# ENG-CDR19004-R4-TS-CD-Redlines .pdf Markup Summary

**MERIDIAN ROAD STREET
 IMPROVEMENT PLAN**

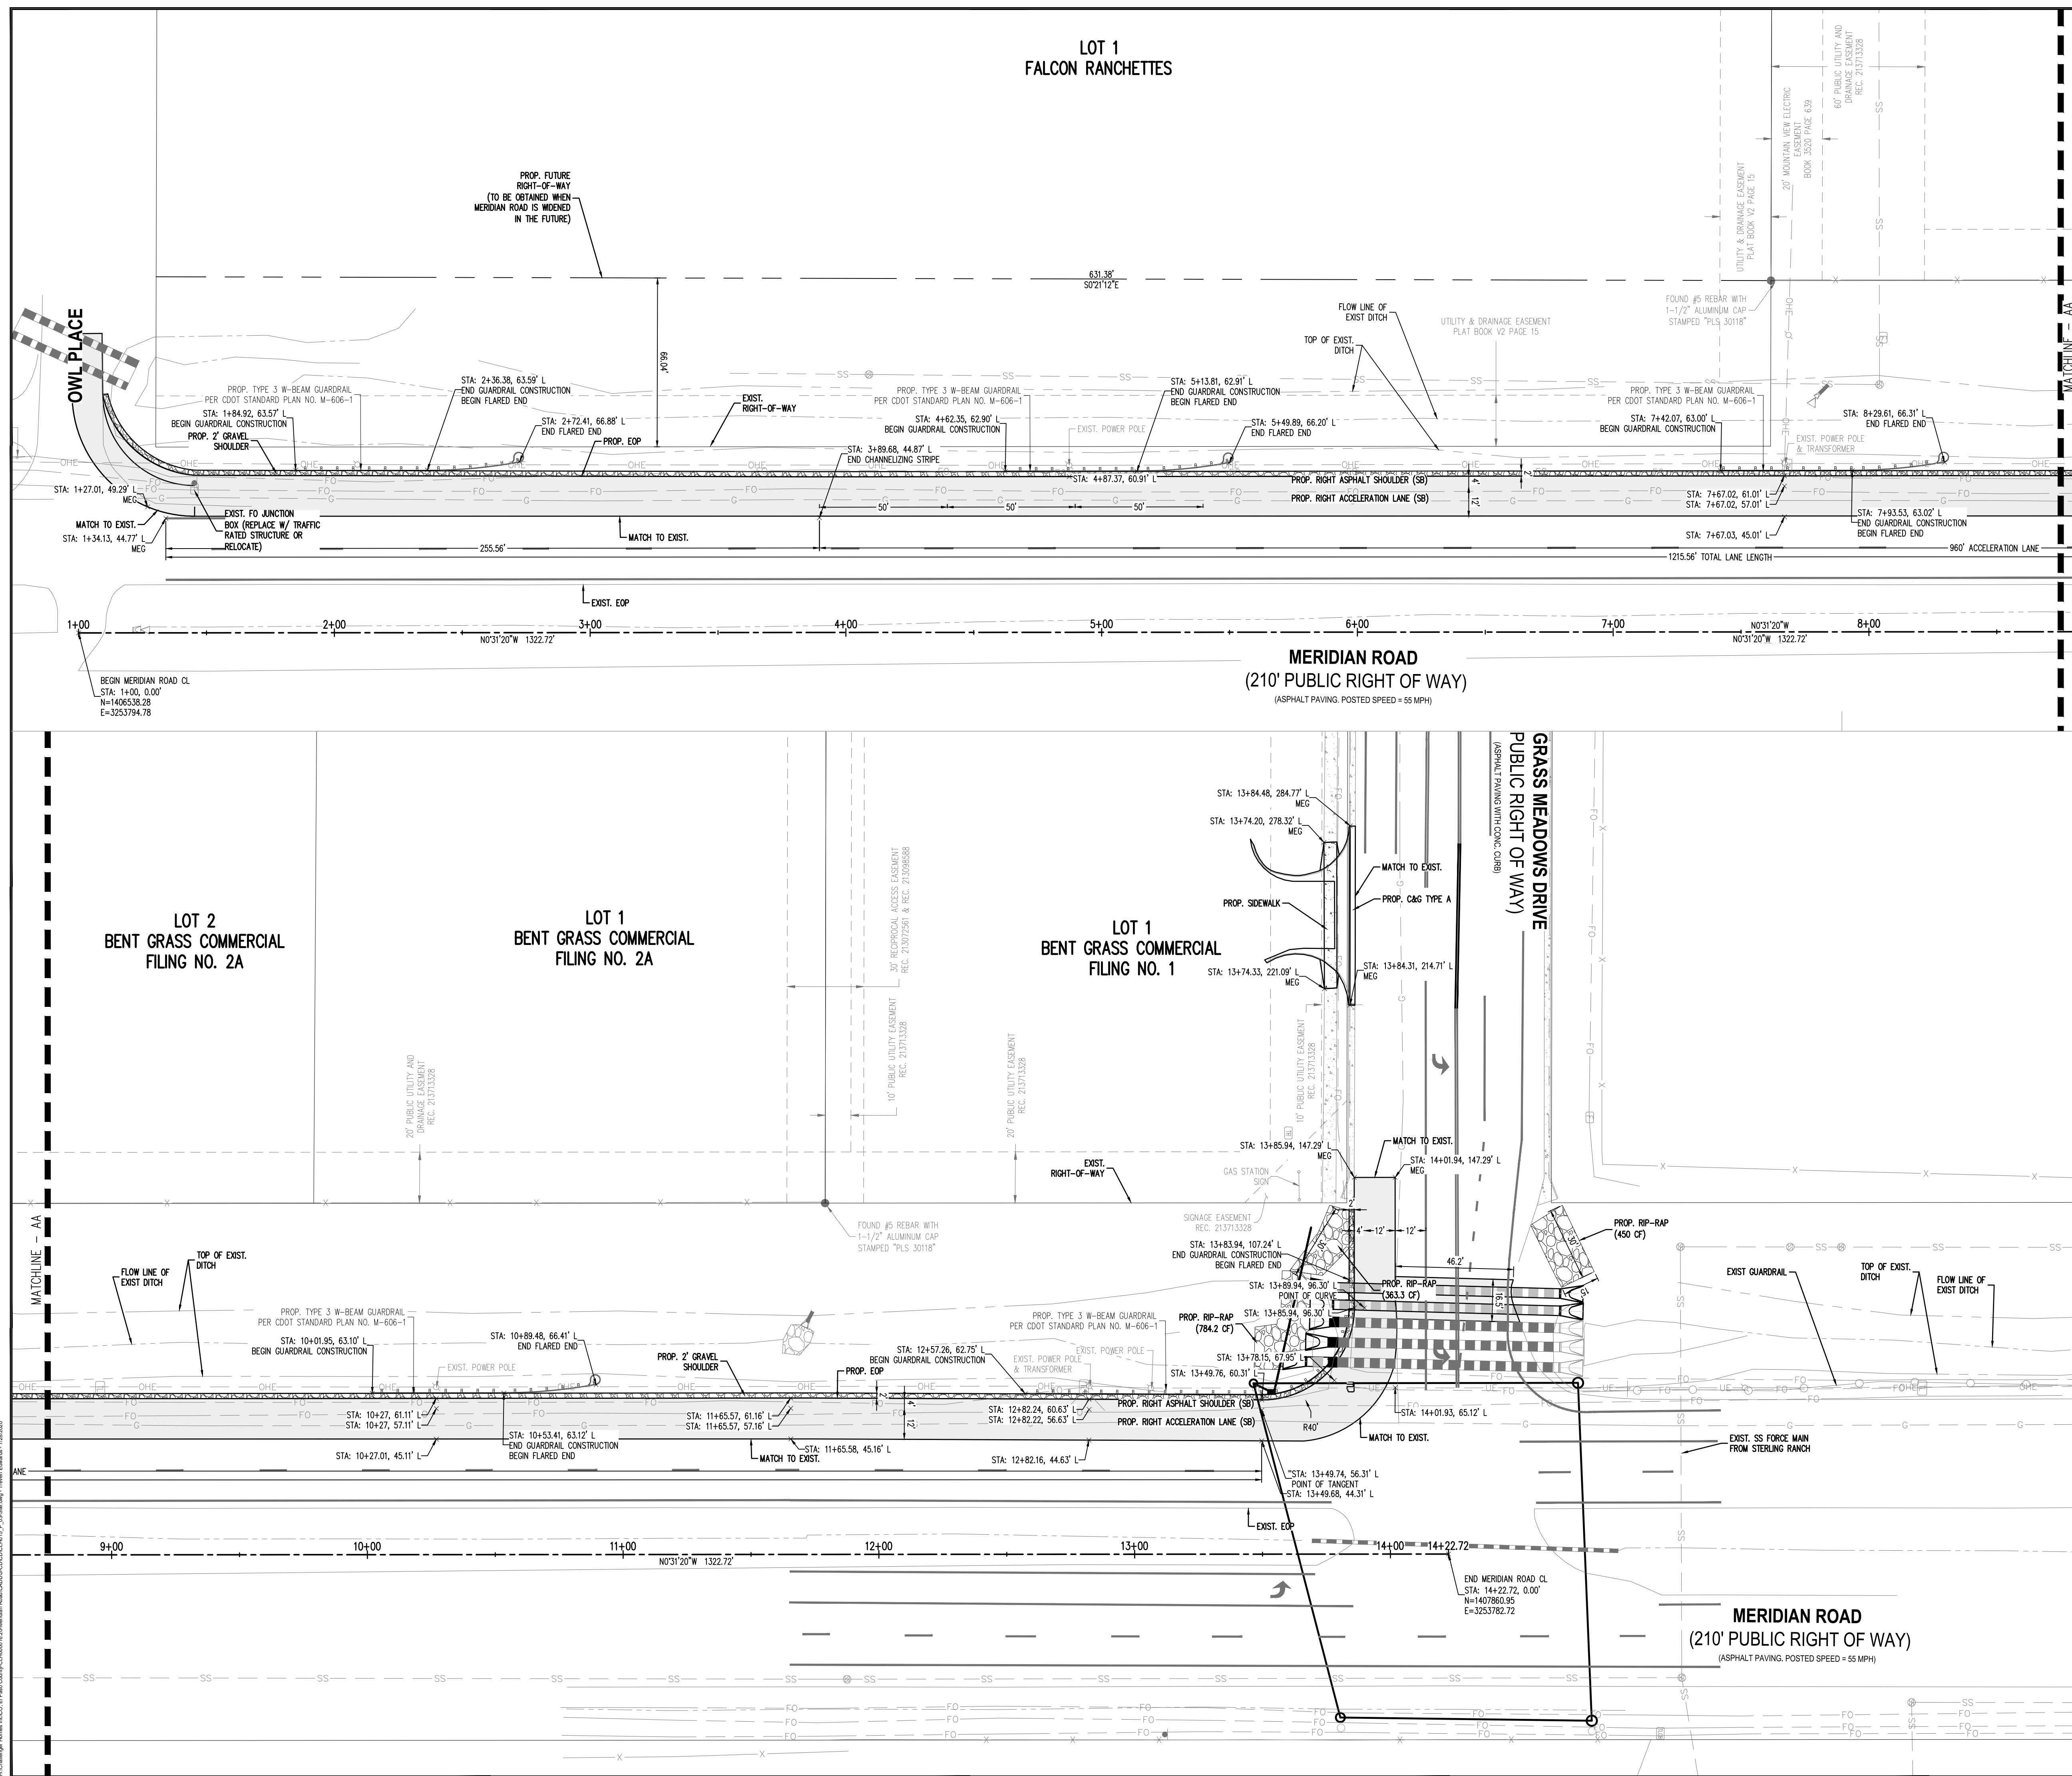
This appears to be in the future sidewalk/trail location. See Galloway exhibit.

radar detection zones?

lighten or gray back the shoulder (change hatch?)

It's not a good idea to provide partial pedestrian infrastructure (without ramps or crossing)

Channelizing island would provide benefits at this location and it might be a better location for the signal pole and lighting.

radar
